From: Martyn White <Martyn.White@arun.gov.uk>
Sent: 28 May 2021 08:56
To: Planning.Responses <Planning.Responses@arun.gov.uk>
Subject: AB/55/21/L

AB/55/21/L

61 High Street Arundel BN18 9AJ

Listed building consent for the removal of the built-in seating, removal of the internal false timber cladding, lowering of height of food service hatch, installation of fold-down access ramp to basement steps, overlay of WC floor materials with single-ply membrane & 1 No. illuminated halo advertisement on front elevation

DRAWING TITLE  
PROPOSED BASEMENT PLAN, FIRST  
FLOOR PLAN AND FRONT ELEVATION

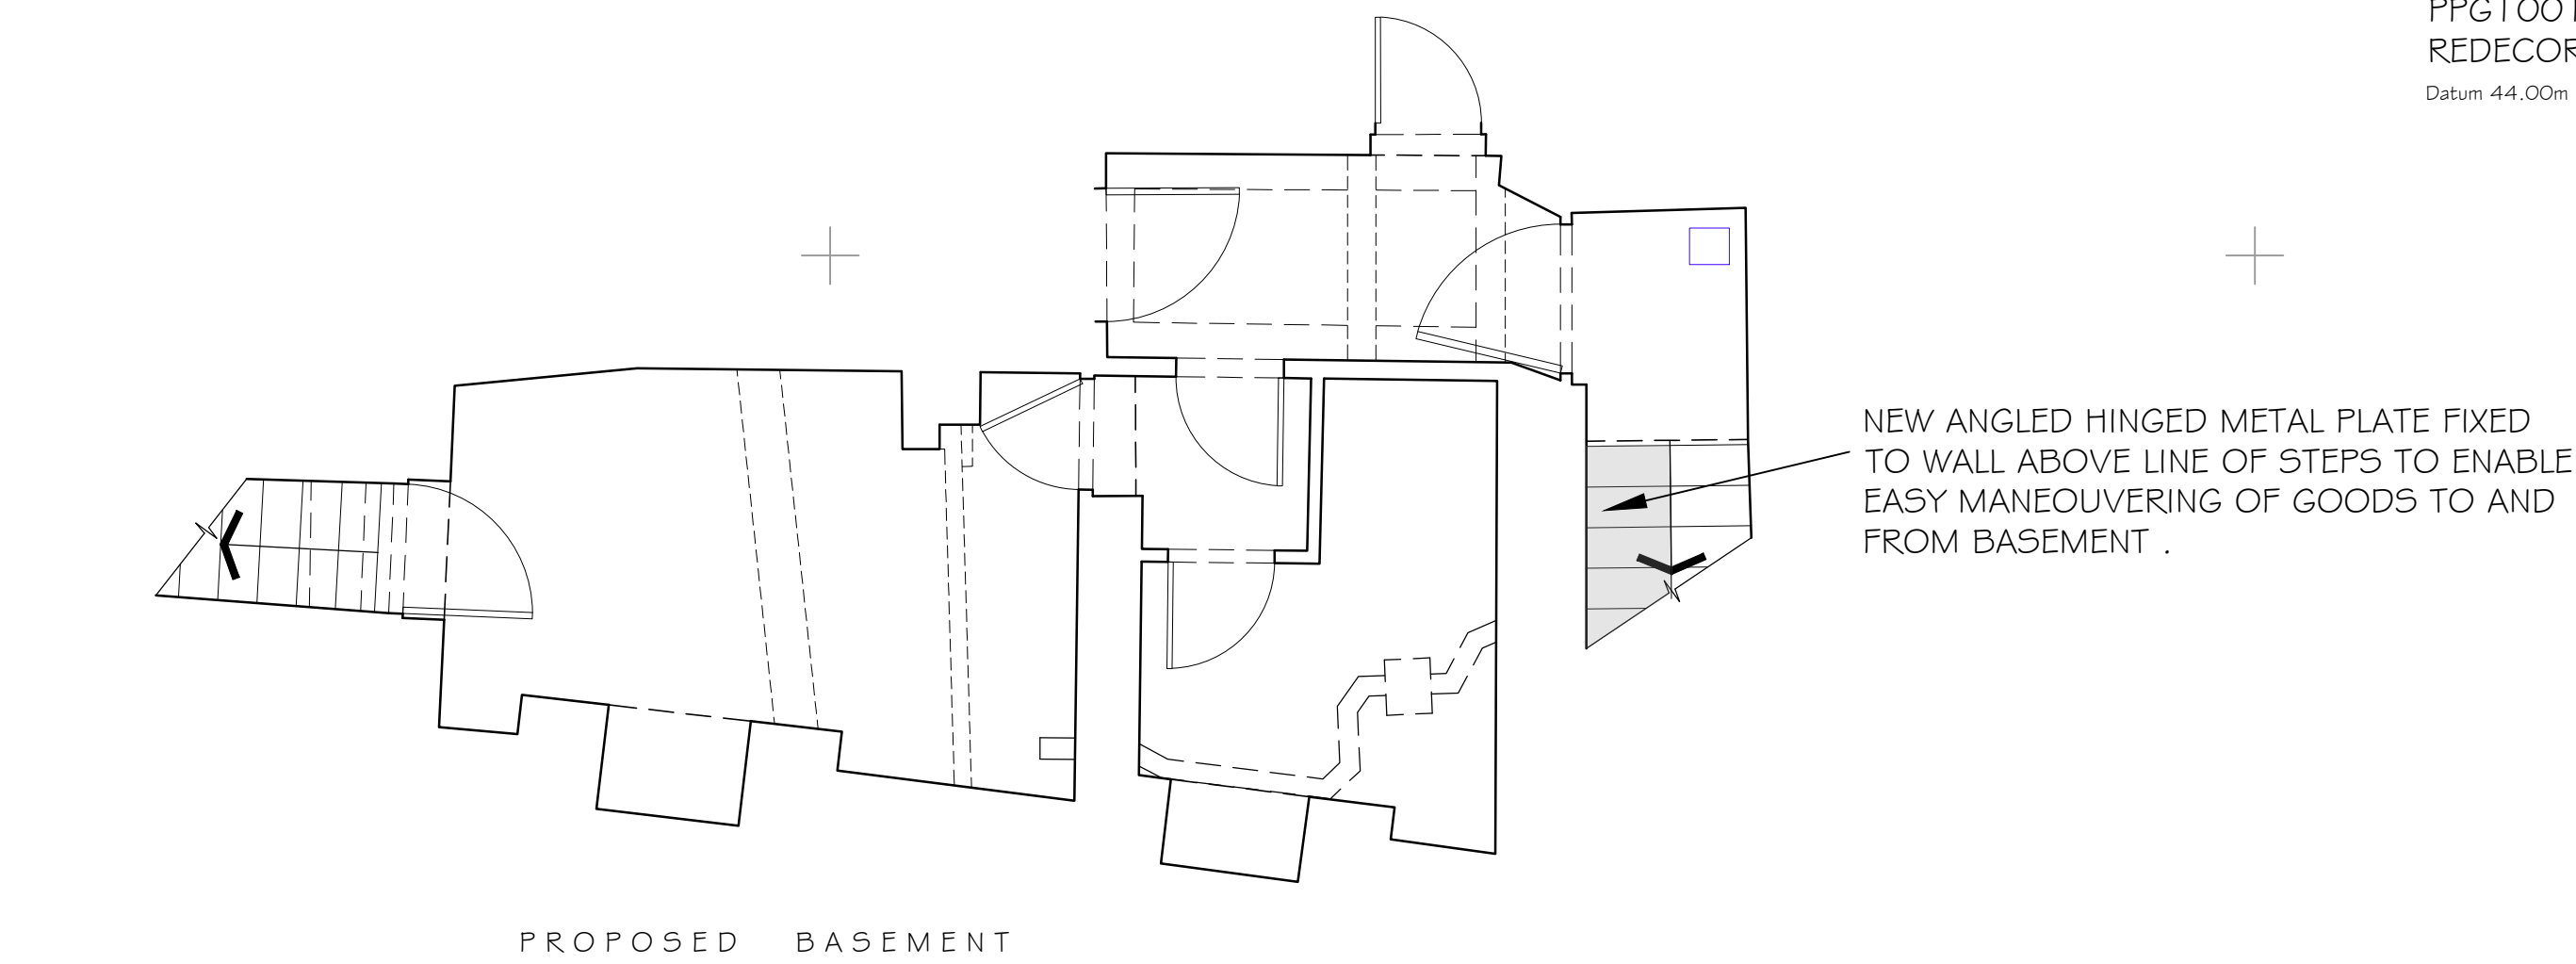
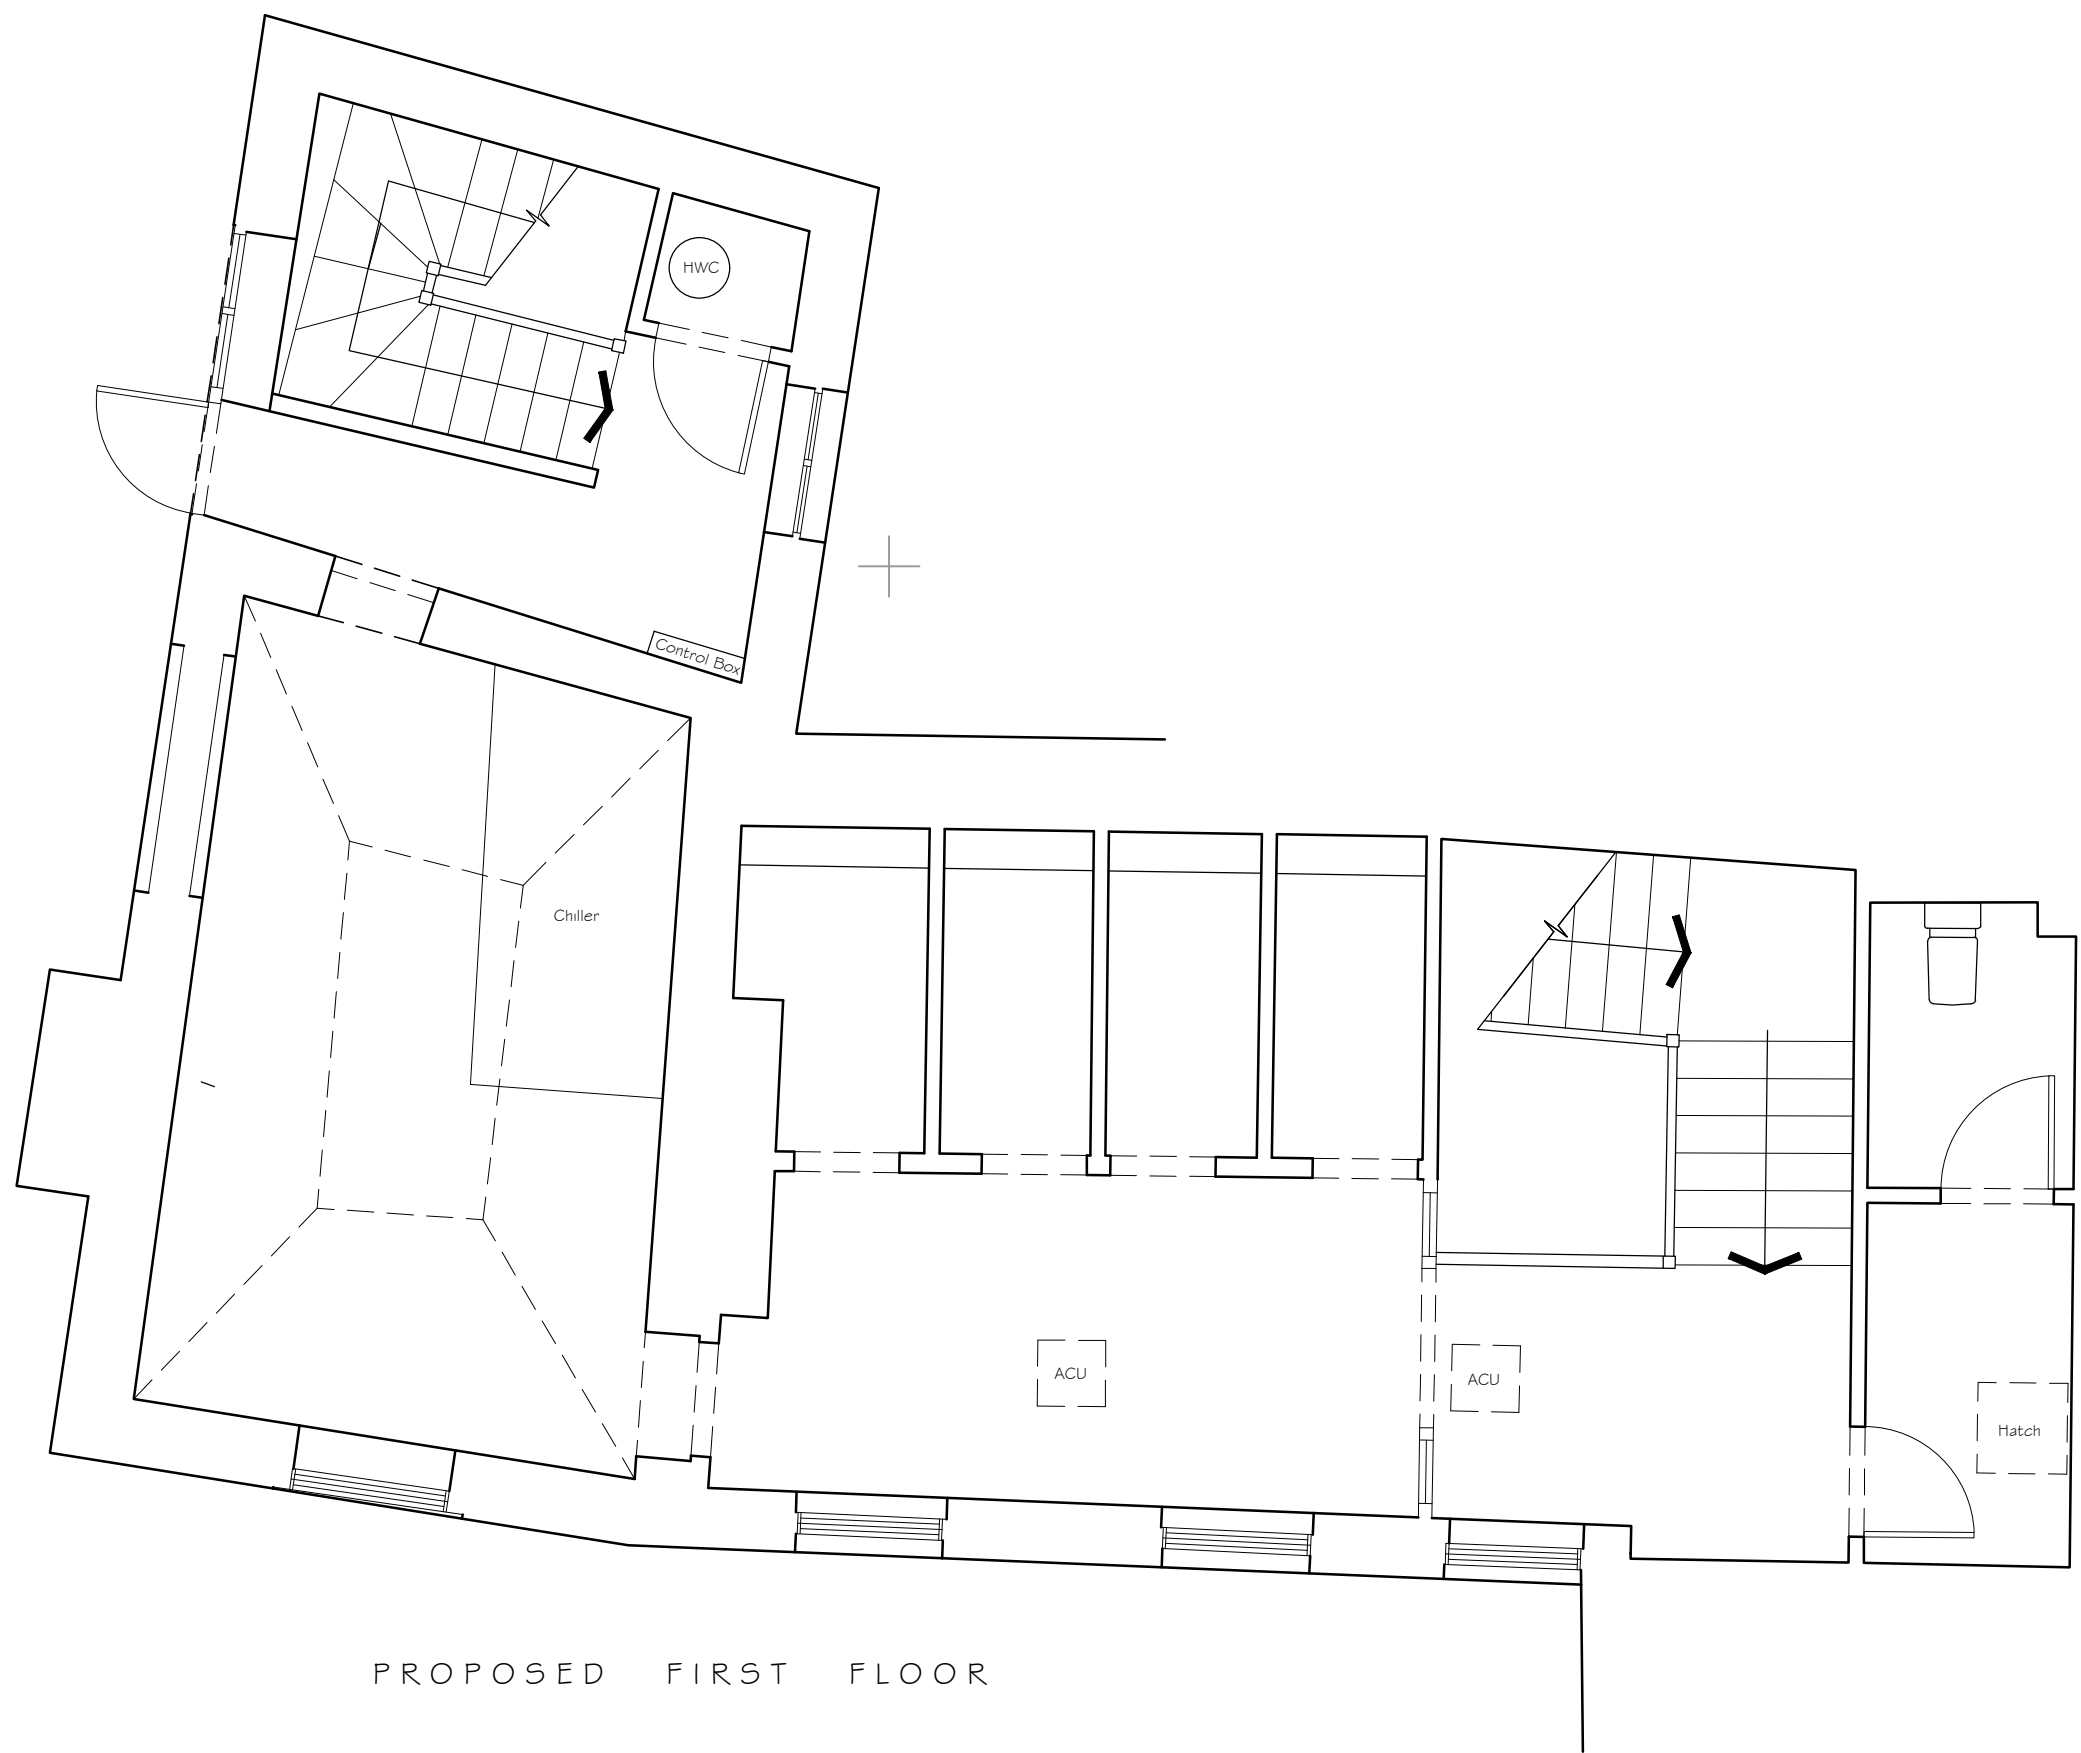
Whilst it is acknowledged that the new metal fold down access ramp to the basement is considered to be a requirement of the restaurant's operation, it would be located so that it could be visible at pavement/street level. The appearance of the ramp could be improved by ensuring

that it is painted black which would then match the colour of the nearby railings. This could be confirmed by way of condition if you are minded to approve the application.

Whilst the lettering of the advertisement is of a reasonably simple design which means that it does not detract from the principal elevation of the building, the proposed colour is somewhat bright, and not fully appropriate for the listed building. However, the materials are considered to be acceptable, with what appears to be a limited amount of lighting. The method of fixing the lettering should be such that it utilises any existing fixing points or is attached into the mortar, as opposed to the bricks.

I also note that substitute plans have been provided which propose that the ground floor windows/window sills and railings are painted a grey colour and that new wall mounted external lighting is installed between the ground and first floor windows. I am of the opinion that changing the colour of the ground floor windows / window sills with a colour such as that proposed would mean that it would be different from the remainder of those on the front elevation. This would look awkward and out of character with the building, which was originally designed/constructed as a private residence where all of the windows should remain the same colour. Further, it is not clear how a grey colour would be appropriate for this listed building or the railings to the front of it.

It is not clear why additional lighting is required for a building which is located in a town centre. It is considered that location lights on this elevation would be out of character with the age and appearance of the building and would be harmful.
